WNF Comments on Water Eaton Development Proposals 23/01233/OUT June 2023

The Wolvercote Neighbourhood Forum (WNF) seeks to represent the views (in relation to planning matters) of residents in the Wolvercote Neighbourhood Plan area.

DRAWN	CHECKED	APPROVED
PH	JDW	JDW
PROJECT No:	SCALE @ A1:	DATE:
ITB16565	1:500	13.01.23
DRAWING No:	ITB16565 - SK - 067	
		REV: H

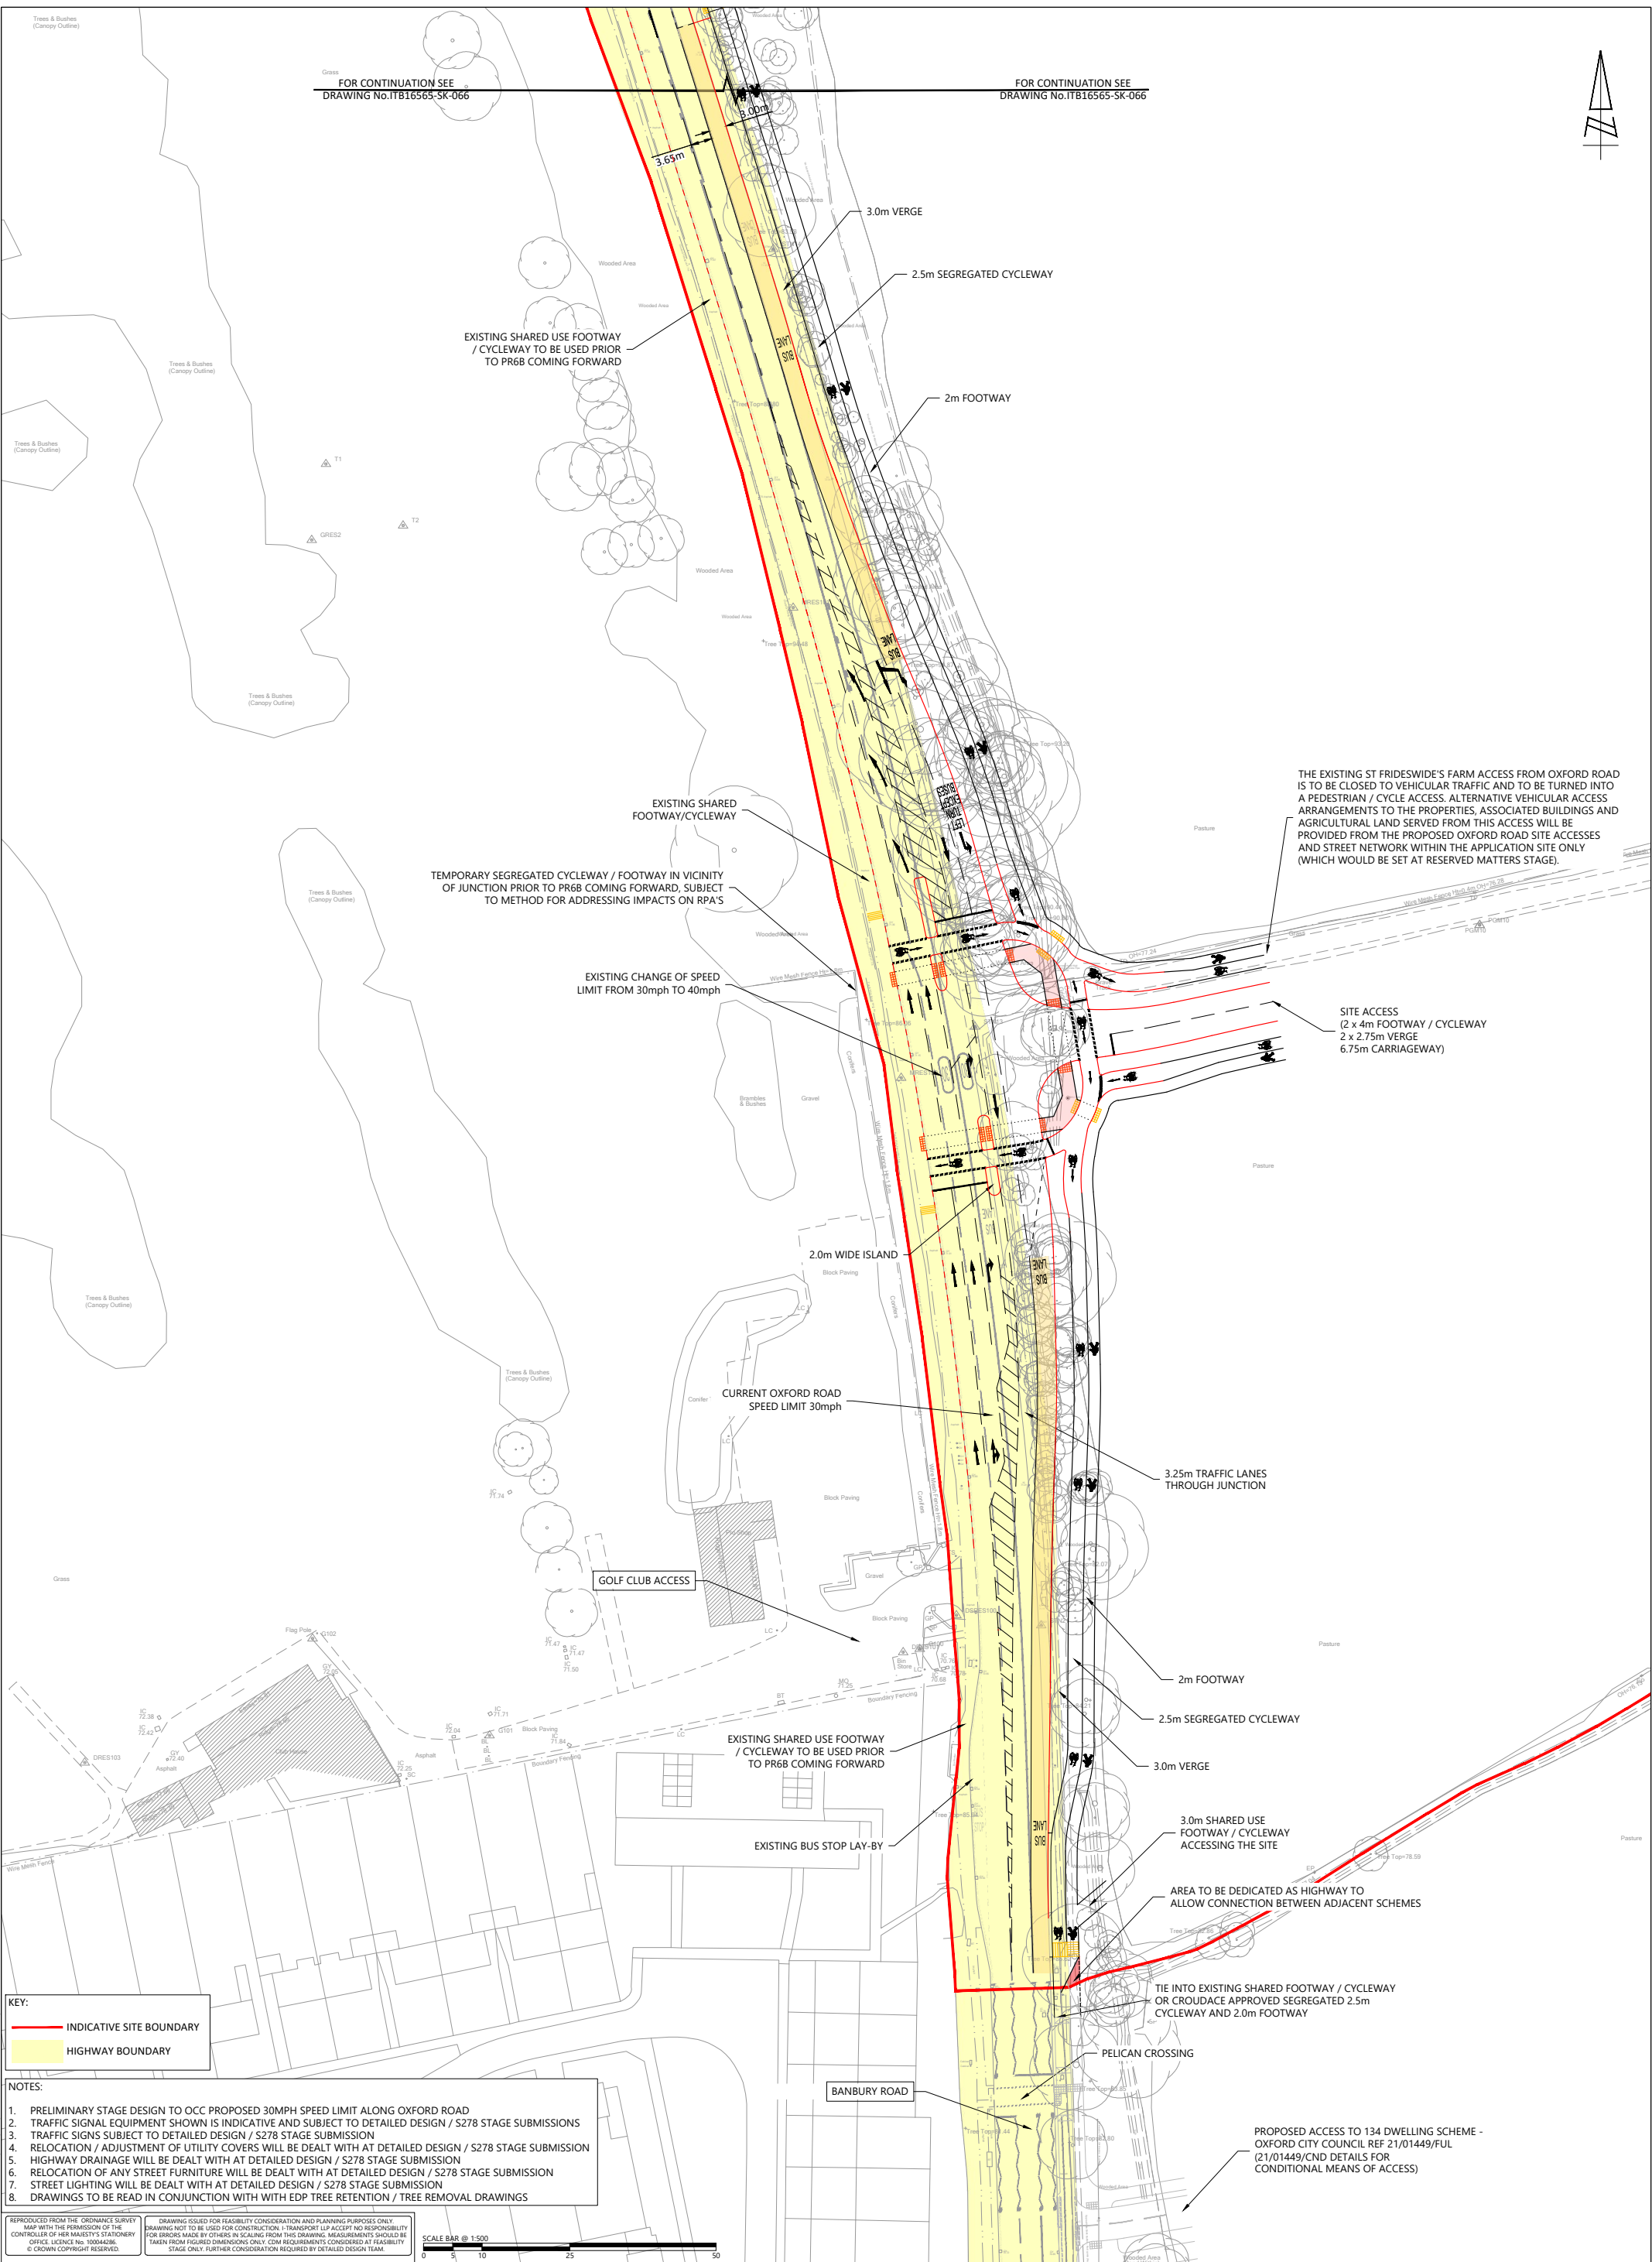
Cycle path – it is really important that cycle paths connect up properly with others in the area to assist in the development of mostly traffic free paths. This is particularly important where a path is intended to access Cutteslowe Park, where currently cycling is not permitted.
